From: Simon Davis
Sent: 15 January 2019 15:06
To: 'Natalie McKellar' [REDACTED]
Cc: Kerry Simmons [REDACTED]
Subject: RE: 261 Aldwick Road, Aldwick. Ref: AW/279/18/RES

As I recall, the final comments from the Tree Officer on the Outline application maintained an issue regarding whether the proposed no dig construction would actually be a no dig construction. However, we decided to recommend approval regardless because layout was a reserved matter and therefore the discussion over no-dig and the impact of the built footprint on RPA's would be more relevant at the reserved matters application. I am not therefore prepared to give any assurances on recommendation or timescale until the Tree Officer has confirmed that he has no objection with the application. However, at the current time, I can advise that I have 20 other older applications to determine before yours. I would therefore not expect to have made the decision (i.e. written the report) until at least the end of February and I would therefore respectfully request an extension of time until February 28th.

Tree Retention and Protection Plan

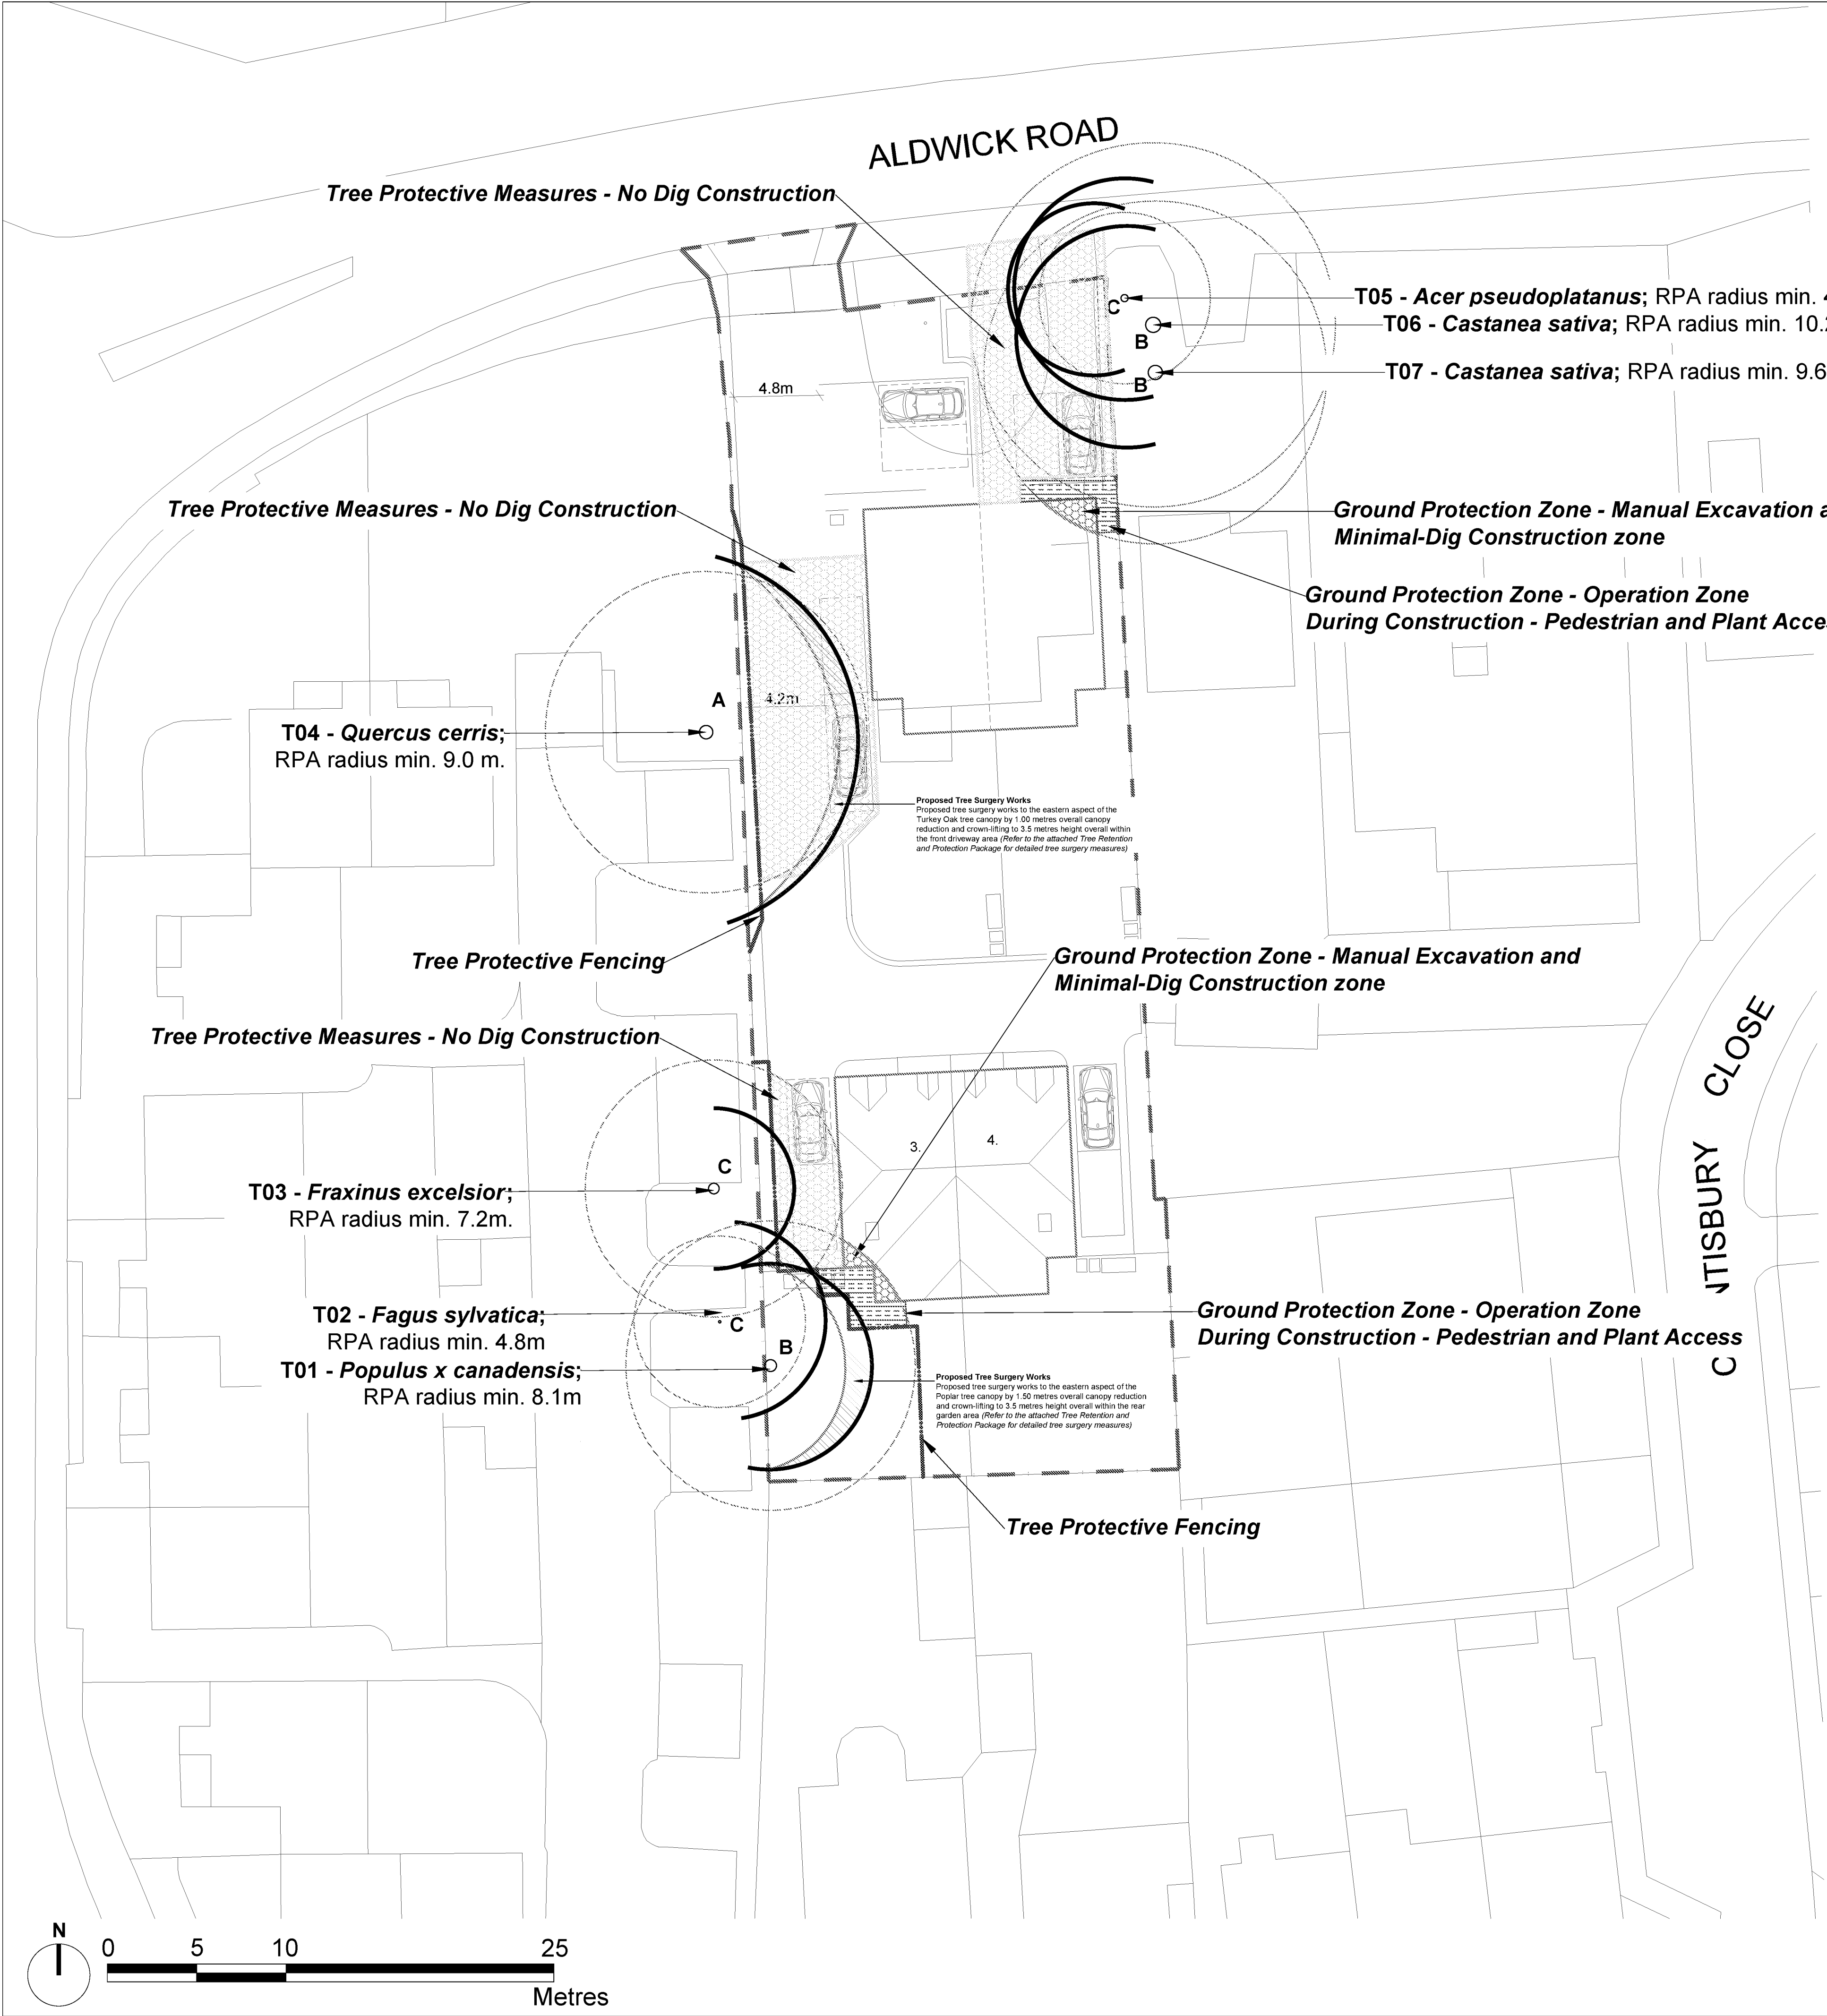
The Tree Officer commented at length on the previous outline application and conditions were attached as a result in order to protect the trees at all stages of the development. Given that this is a reserved matters application it is not reasonable to work on the basis that the tree officer will maintain and be consistent with his previous consultation comments on the outline application. On this basis we are not able to move forward or at least agree to an extension of time to work towards.
